**From:** Simon Davis <Simon.Davis@arun.gov.uk>  
**Sent:** 11 August 2021 15:53  
**To:** Planning.Responses <Planning.Responses@arun.gov.uk>  
**Subject:** FW: Vistry Yapton - Y/72/21/DOC

#### Further Drainage Comments

**Cc:** Paul Cann <[Paul.Cann@arun.gov.uk](mailto:Paul.Cann@arun.gov.uk)>; Karl Roberts <[Karl.Roberts@arun.gov.uk](mailto:Karl.Roberts@arun.gov.uk)>  
**Subject:** RE: Vistry Yapton - Y/72/21/DOC

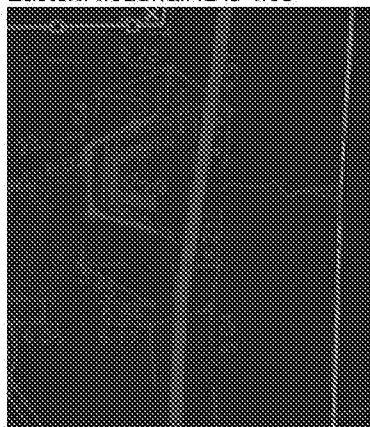
I'm not having much luck in deciphering the images either. Well, the smaller, top one is the headwall where the pumping station (or gravity line) would discharge into the ditch. This is something that Paul would be interested in, if he hasn't already looked at the watercourse consent (separate to Planning)

I think Vistry have got the wrong end of the stick with the larger image. There's no North point but assuming it is 'north-up' then it looks to be the area circled below, approx. 90m from the southeast (not northeast) corner of the Vistry site.

In any event, what I think Karl wanted (and I agree) is information relating to how far they have gone 'off-site' to find a point at which a gravity solution could be found (by re-grading the ditch) – and what the implications would be along the way. We understood that several hundred metres had been surveyed (3.5.1 of the Technical Note) and it was this info that we were interested in. I may be missing the point but I cannot see the relevance of an extract of a drawing showing the corner of a field 90m from the site.

Eastern headwall IL is 4.09

Lowest ditch level north east of site from topo is IL 4.50
